EROSION AND STORMWATER QUALITY CONTROL PERMIT (ESQCP) EL PASO COUNTY APPLICATION AND PERMIT

SOLACE OF COLORADO SPRINGS: LOT1 (PHASE 1)

SOLACE APARTMENTS FILING NO. 1

LOCATED IN THE SW1/4 OF THE NW1/4 SECTION 7, TOWNSHIP 14 SOUTH, RANGE 65 WEST OF THE 6TH PRINCIPAL MERIDIAN
COUNTY OF EL PASO, STATE OF COLORADO

# SOLACE APARTMENTS FILING NO. 1

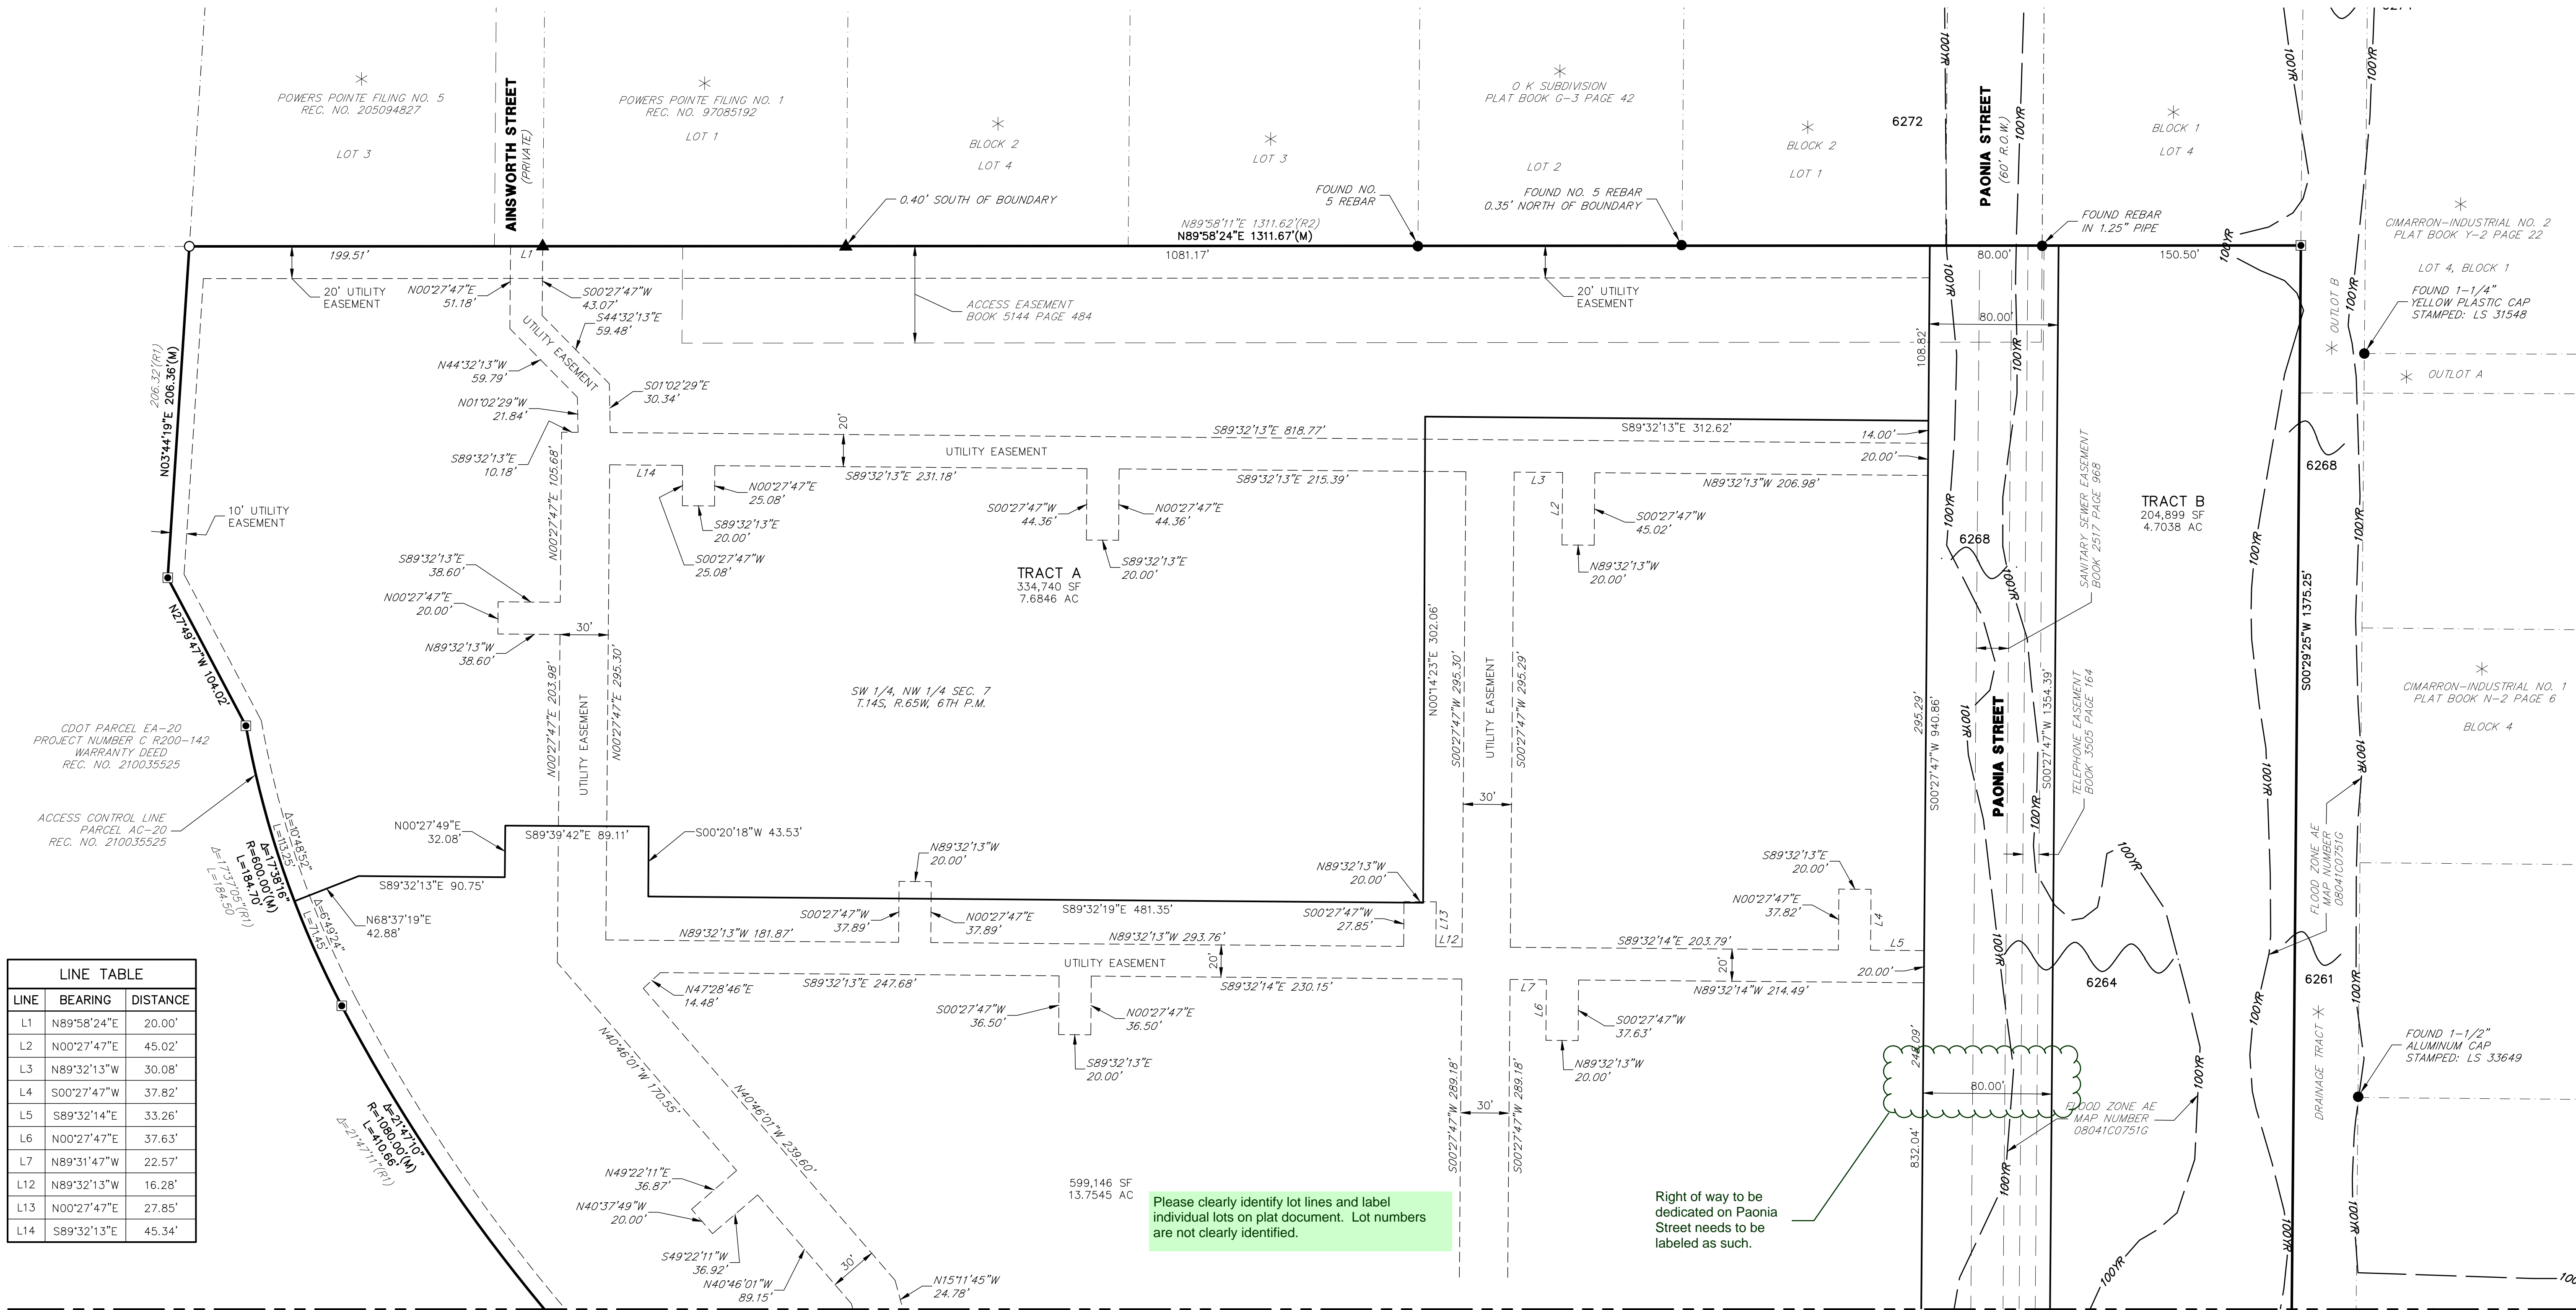
Add note stating that the area depicted as floodplain is dedicated as a no-build area.

ADDED NO-BUILD STATEMENT
